# SOLACE OF COLORADO SPRINGS

## PRELIMINARY PLAN

SP-20-001

# Prelim Plan\_V2.pdf Markup Summary

PRELIMINARY PLAN

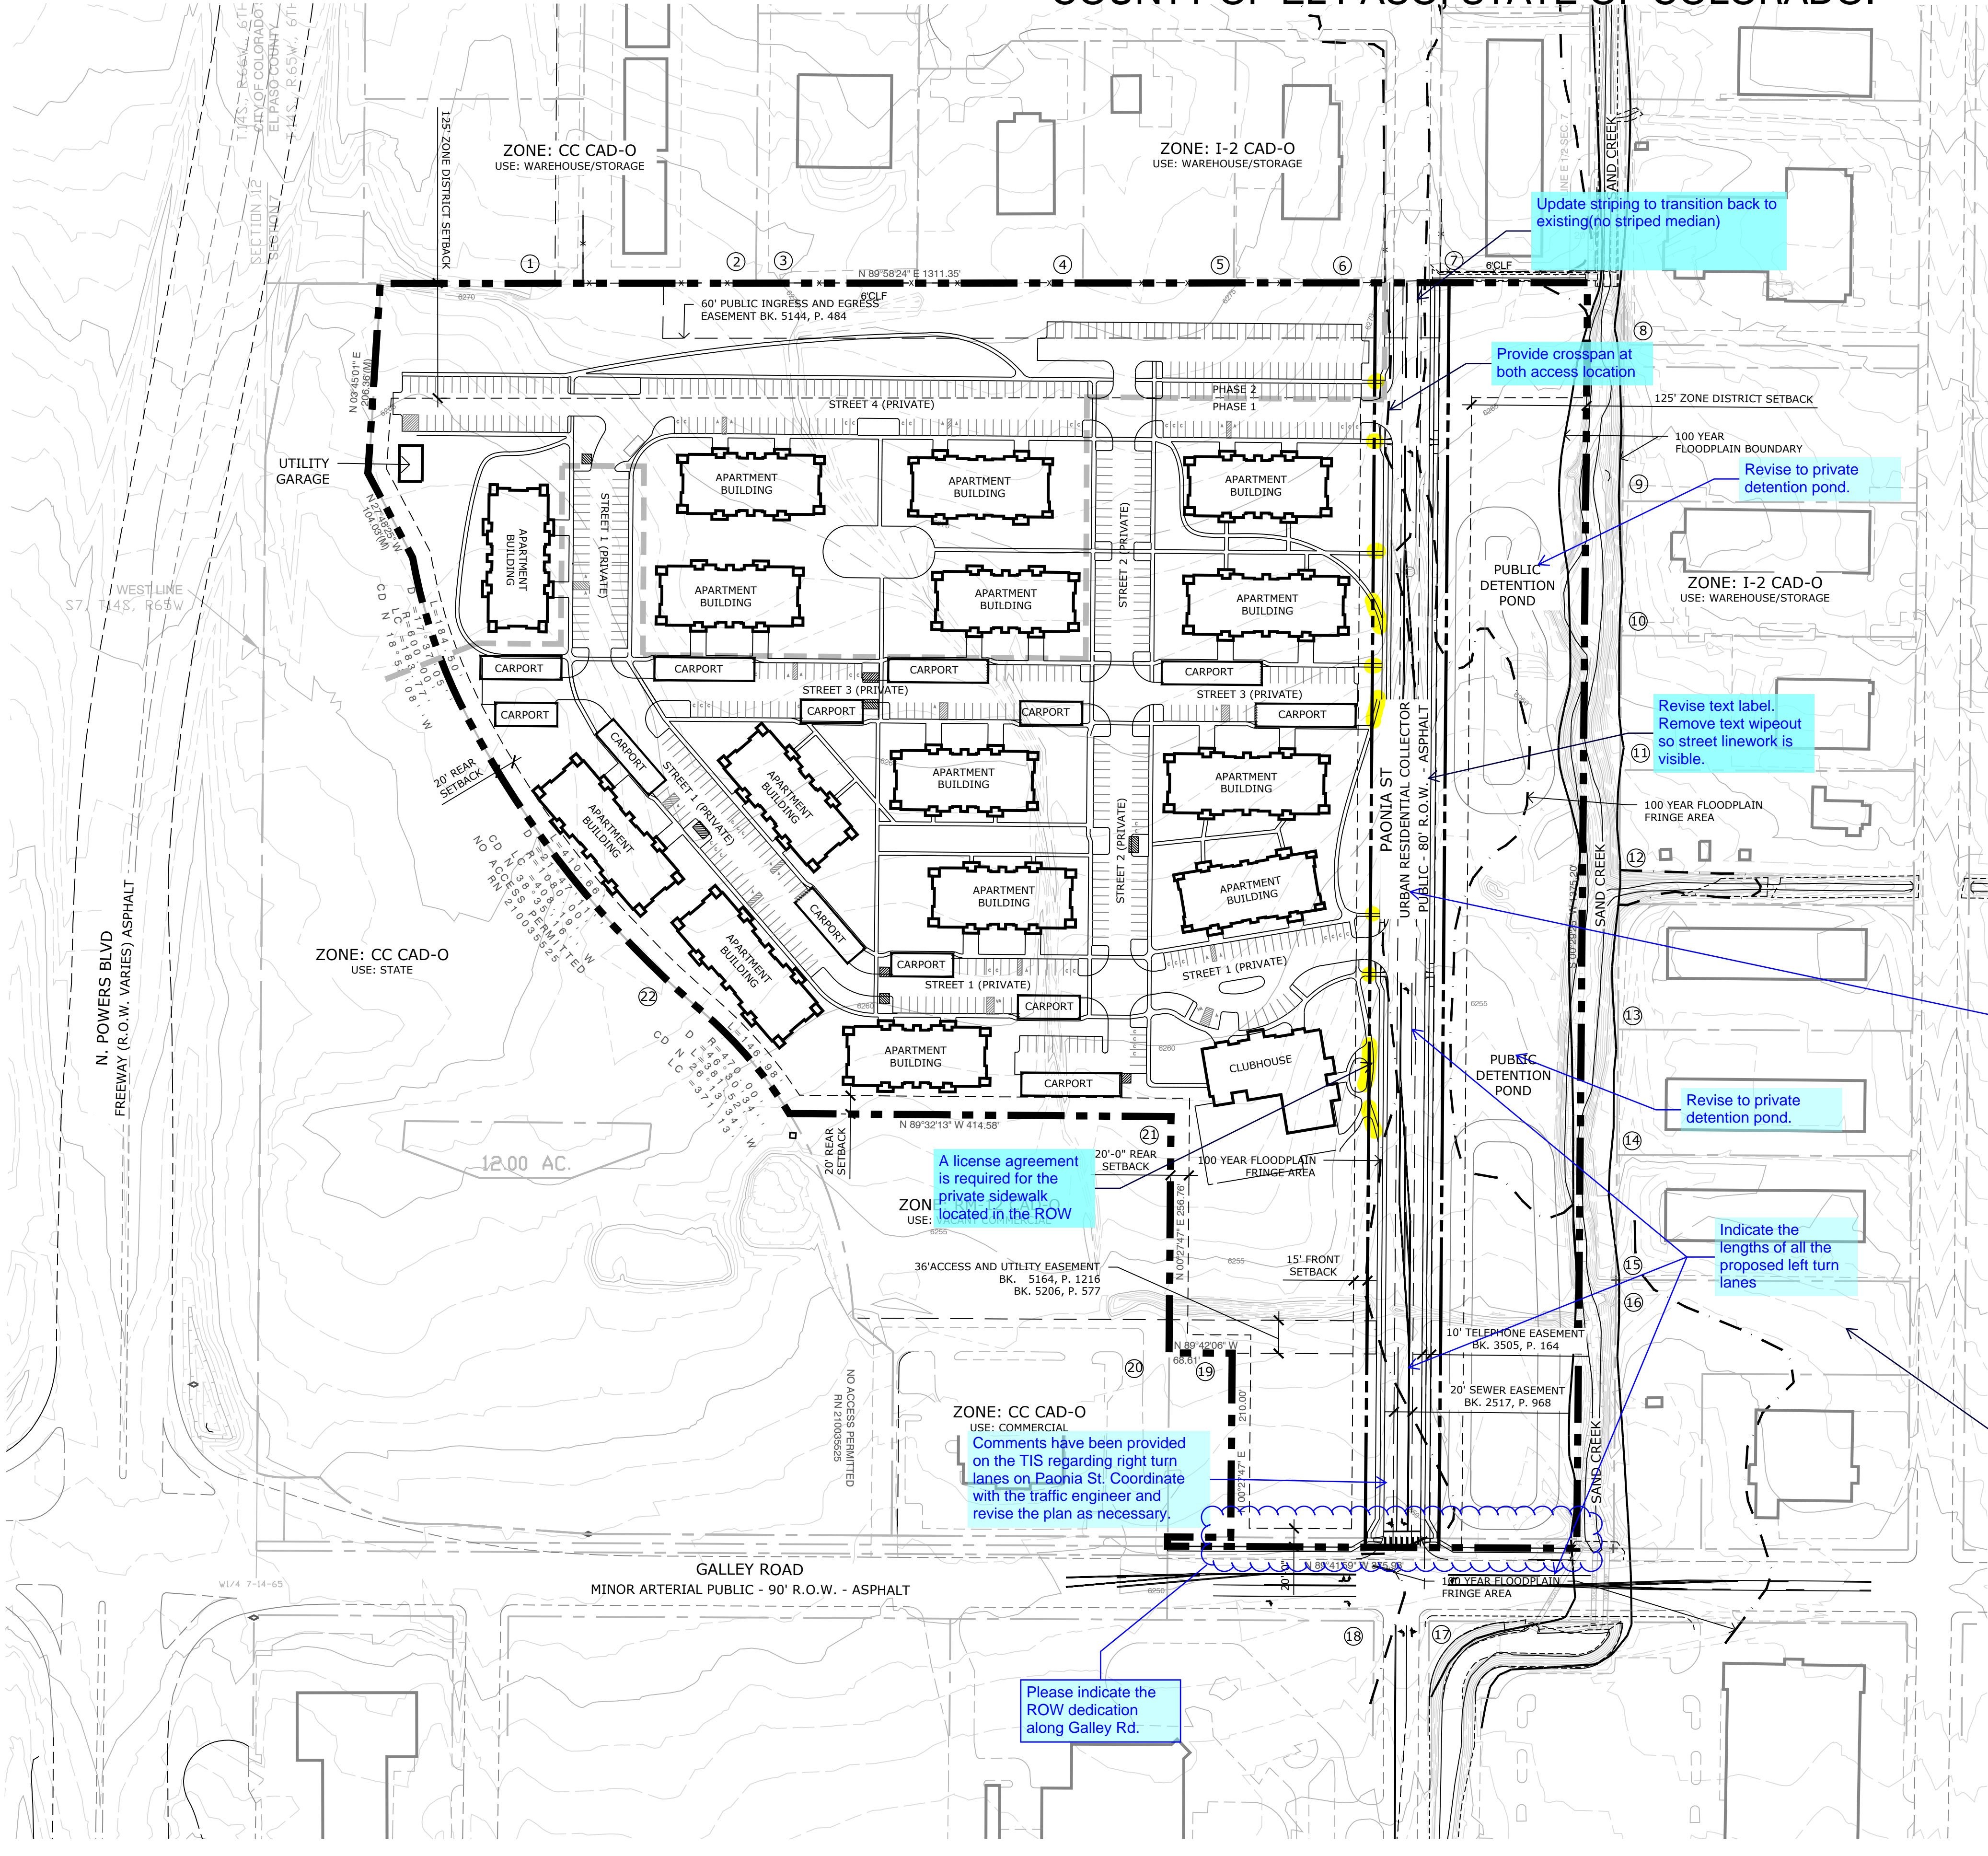
Review 1 comment:  
Update striping to transition back to existing (no striped median)  
Review 2: Unresolved on this sheet.

Review 1 comment:  
Provide crossspan at both access locations  
Review 2: Unresolved.

Please indicate the length of the turn lane.

Please revise the lane length per the TIS/ECM criteria. Coordinate with the traffic engineer.

Per traffic volumes in the TIS an exclusive right turn lane is required per ECM criteria. Note that this is also a recommendation indicated in the TIS. Please revise to show the exclusive right turn lane on all plan sheets.

### PRELIMINARY GRADING PLANS

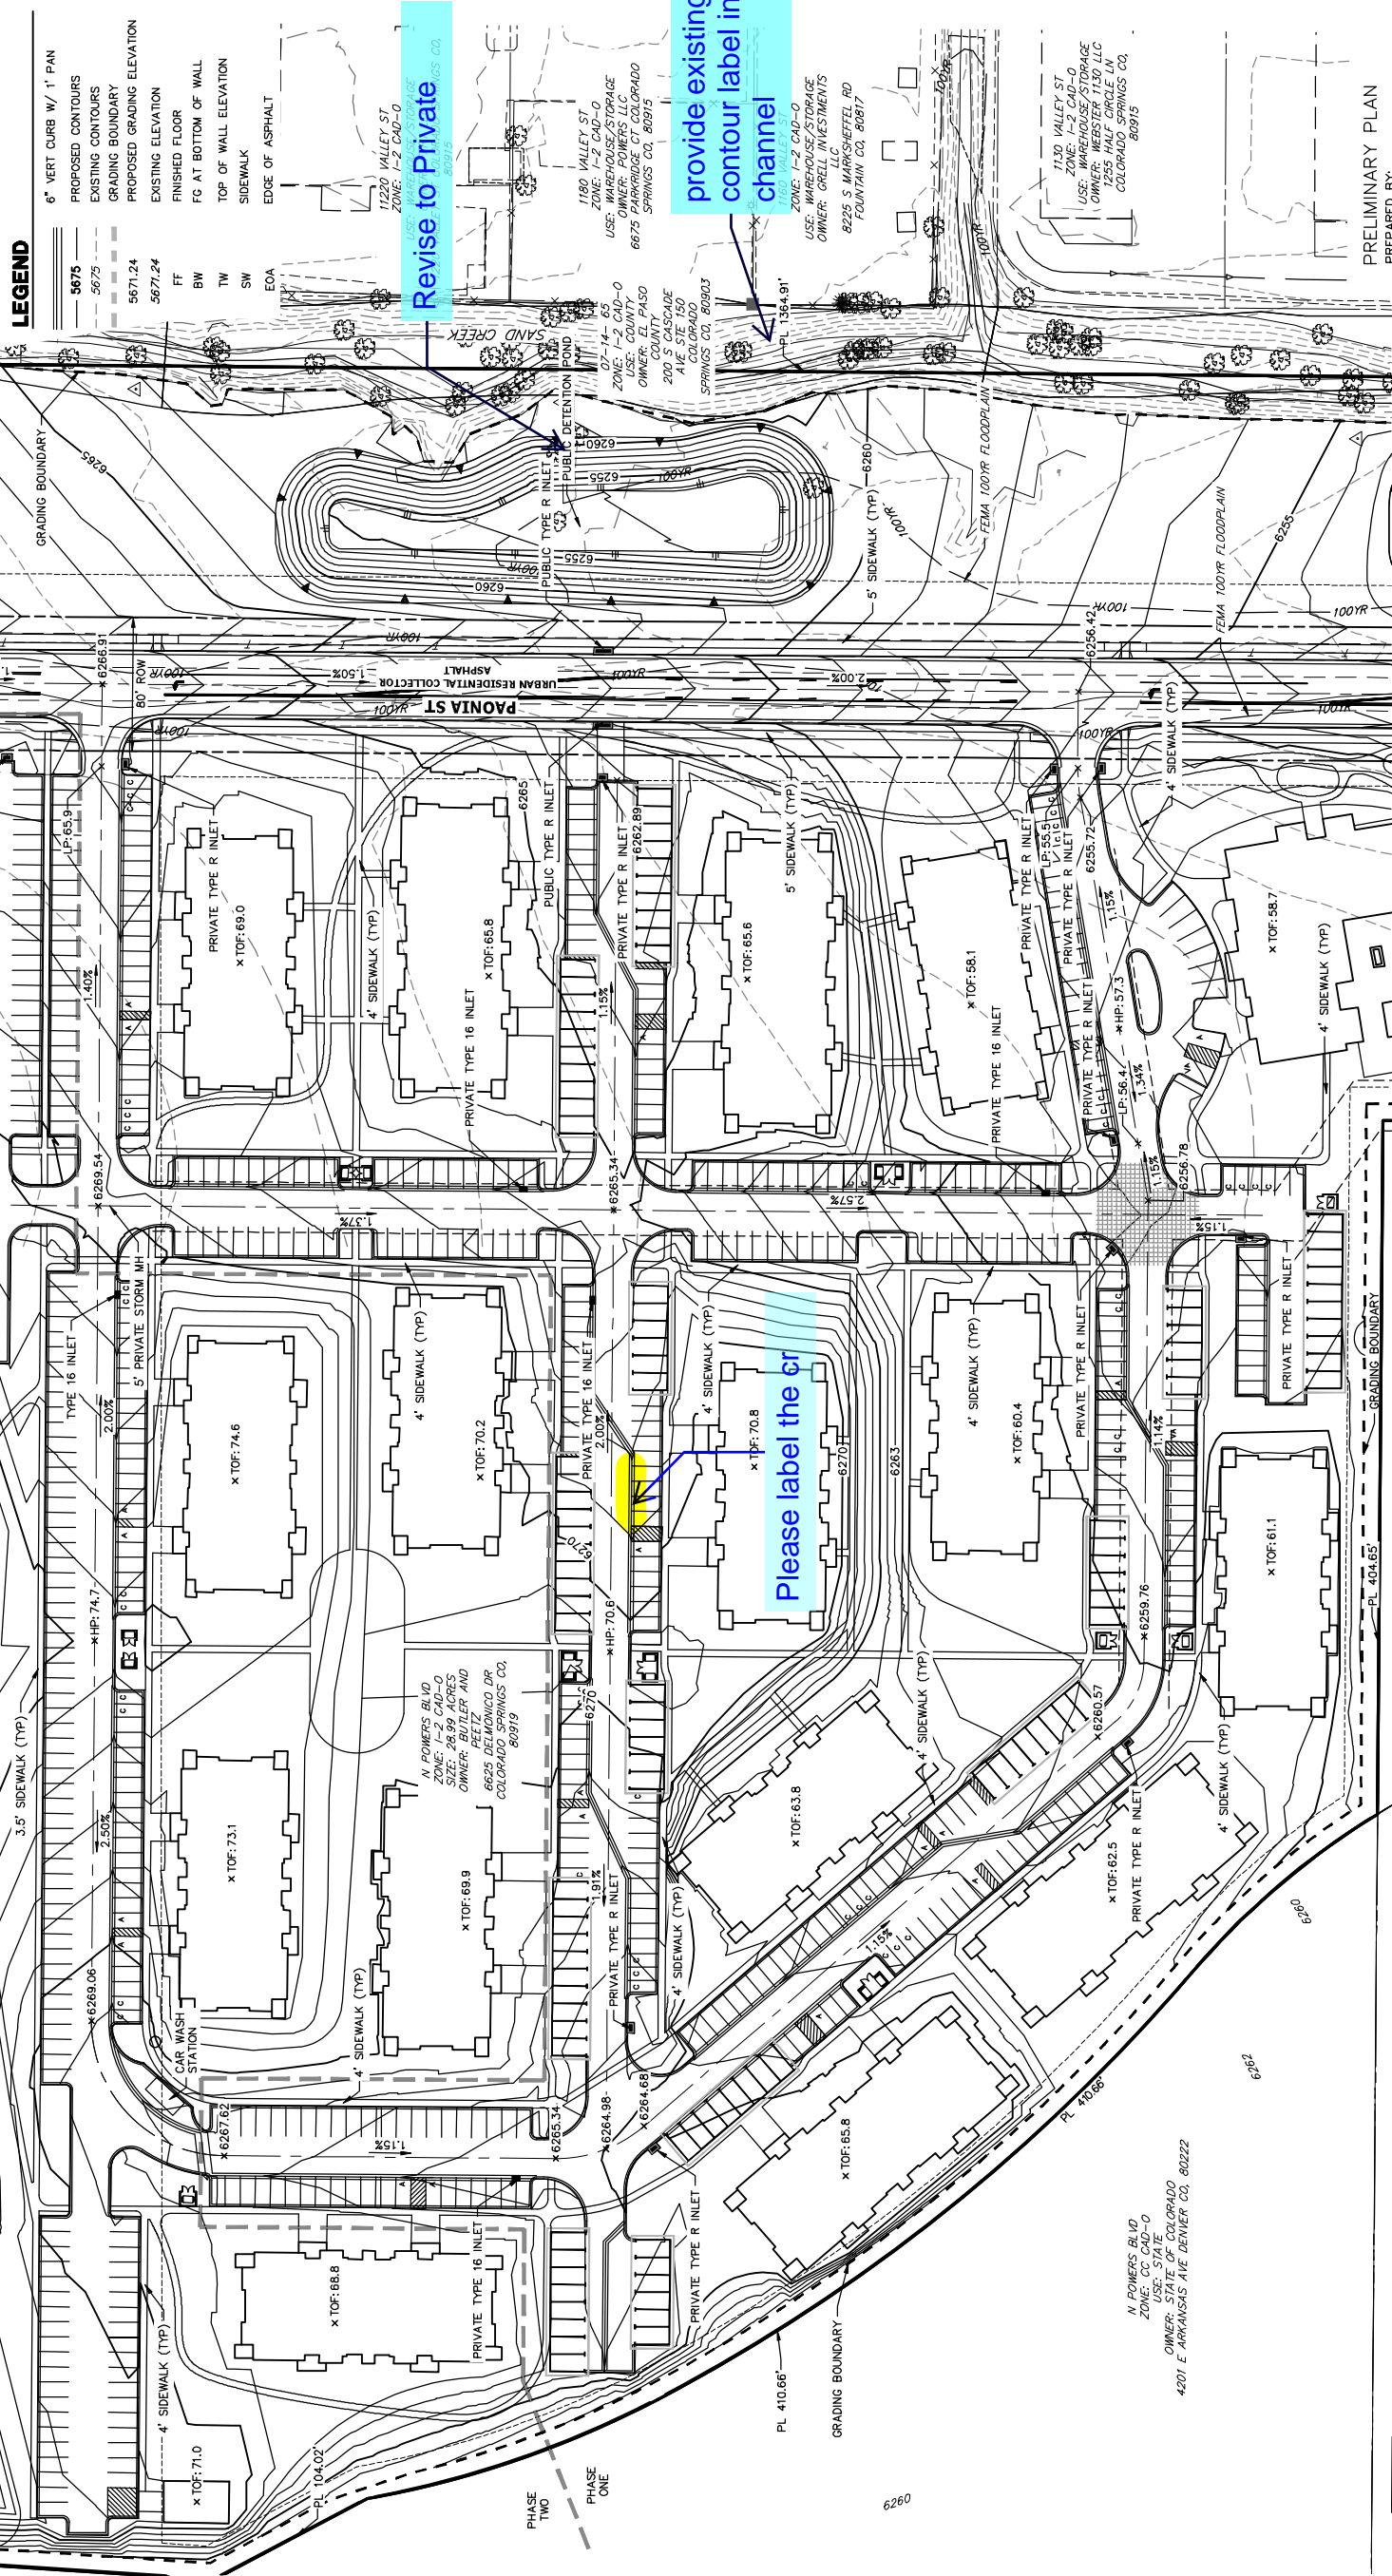
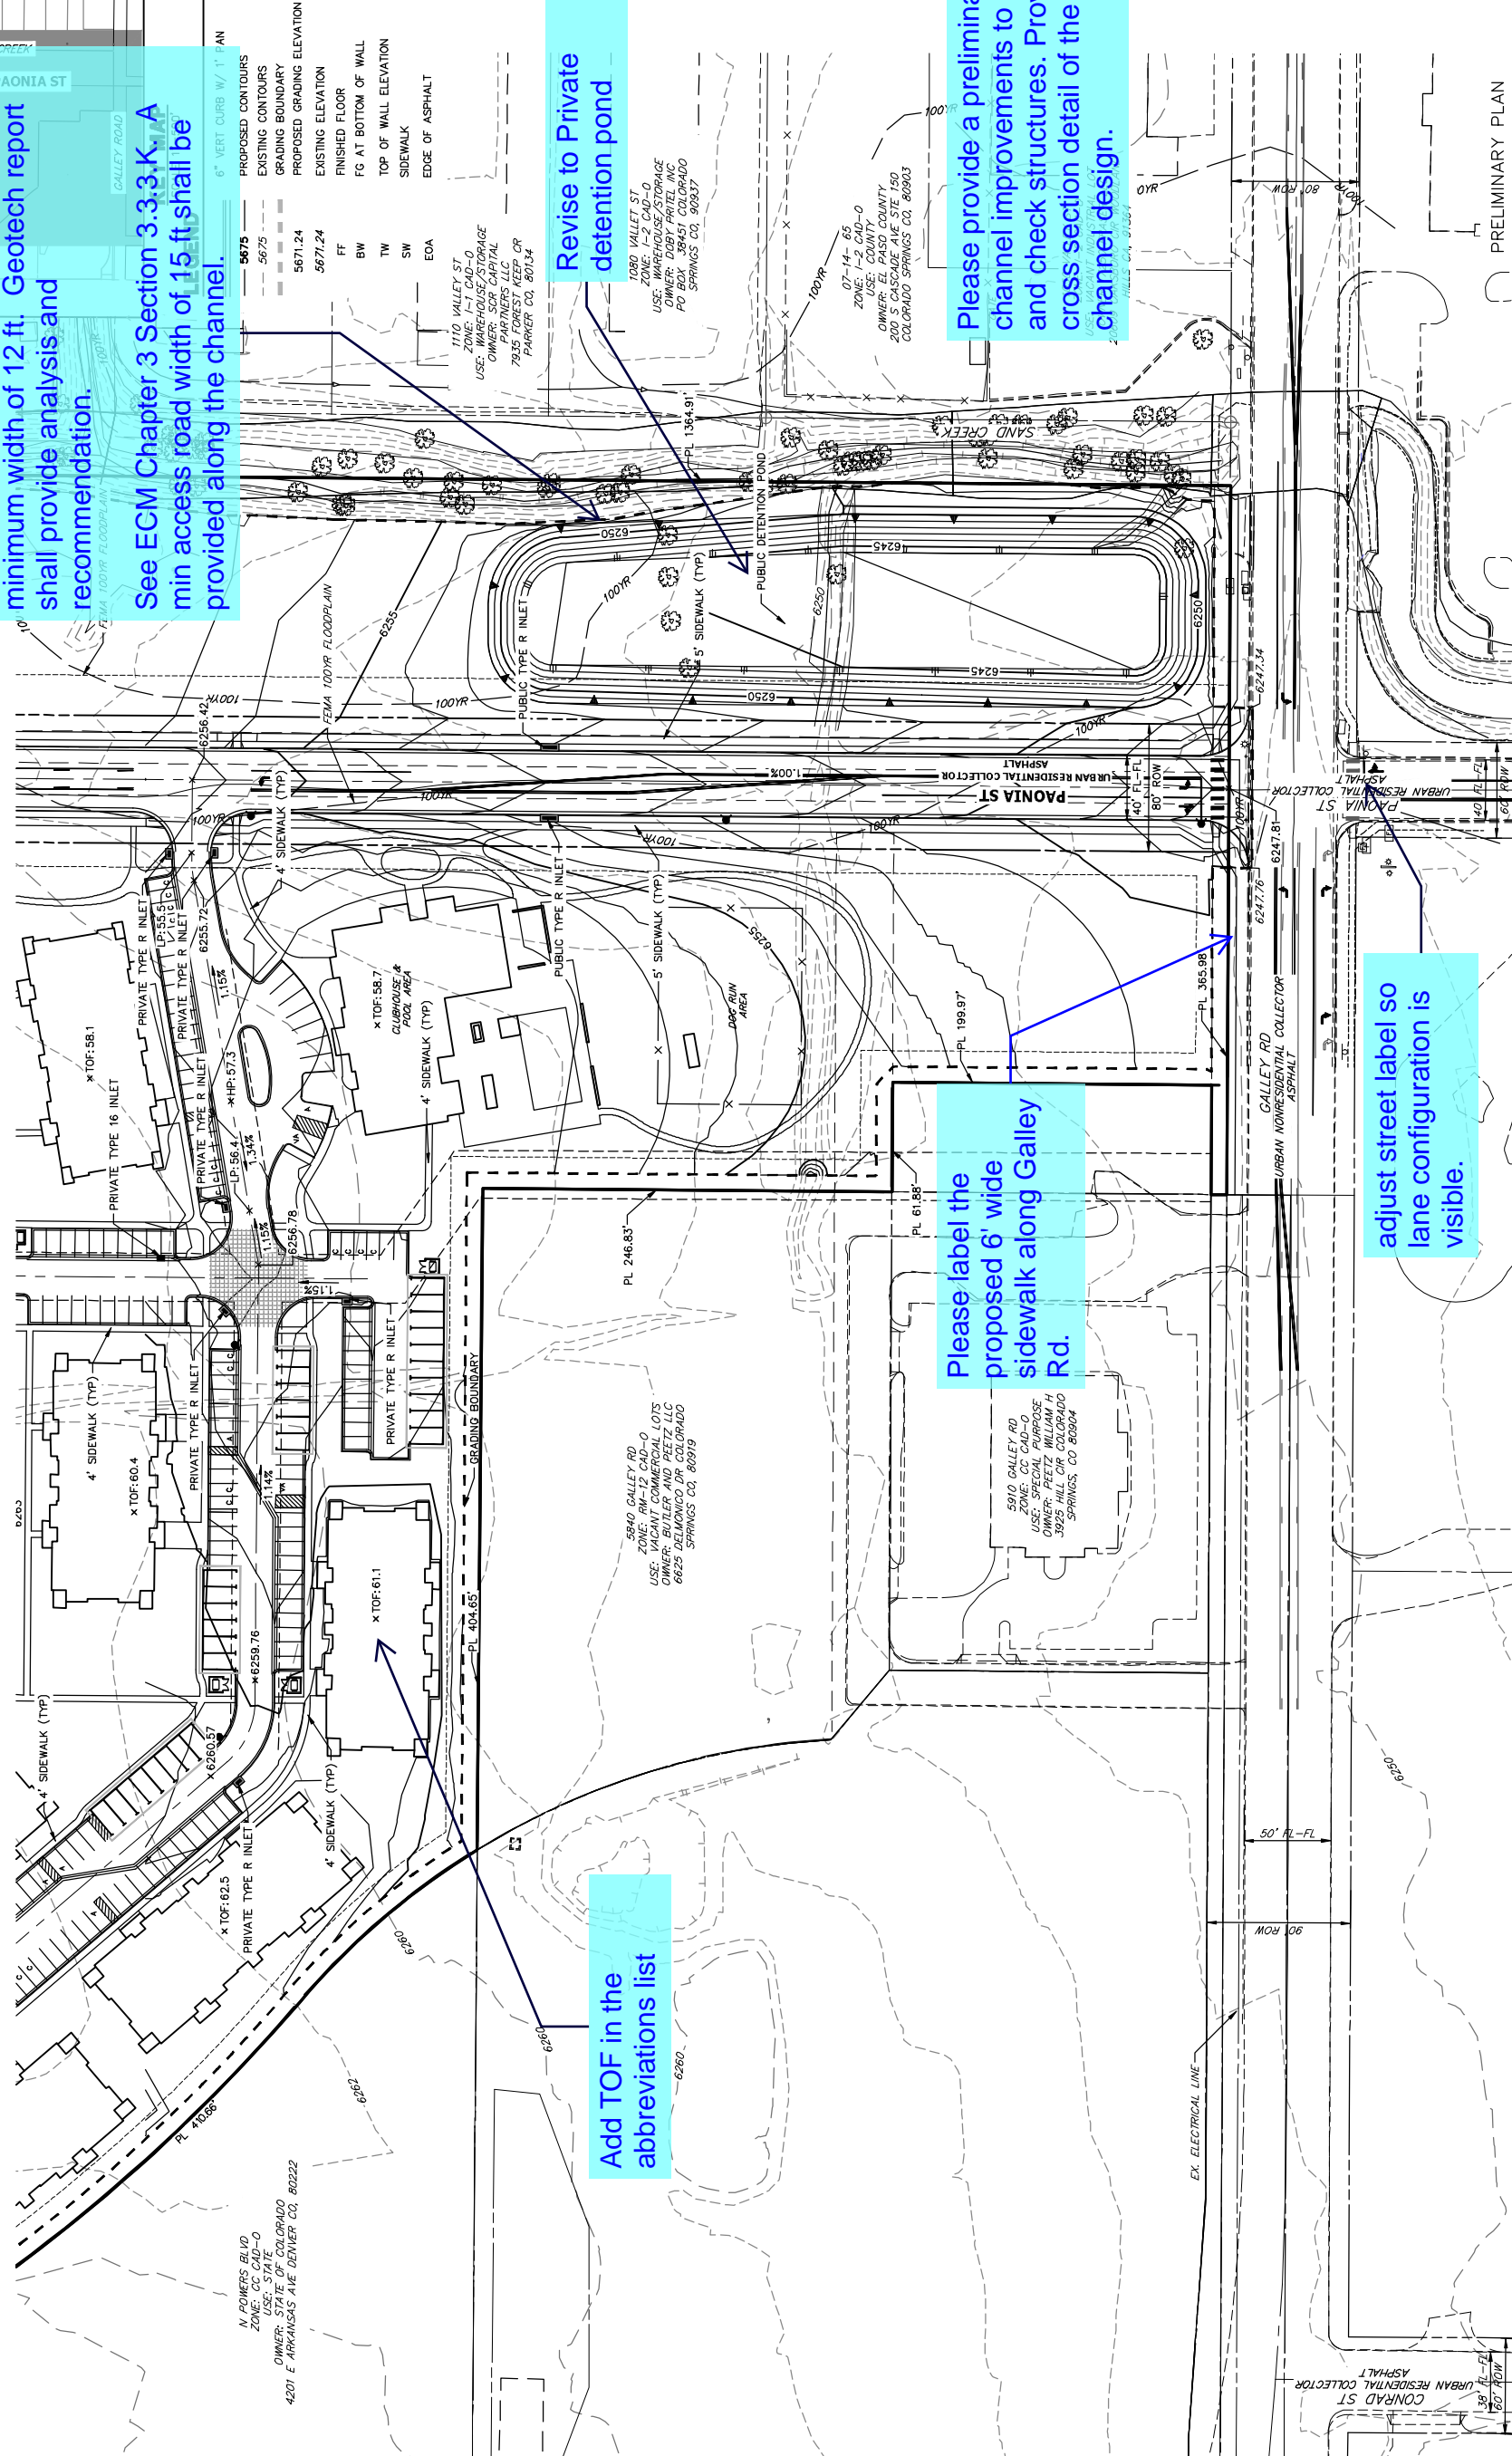
Review 1 Comment: Please provide a preliminary design of the channel improvements to include the drop and check structures. Provide a typical cross section detail of the proposed channel design.  
Review 2: Unresolved
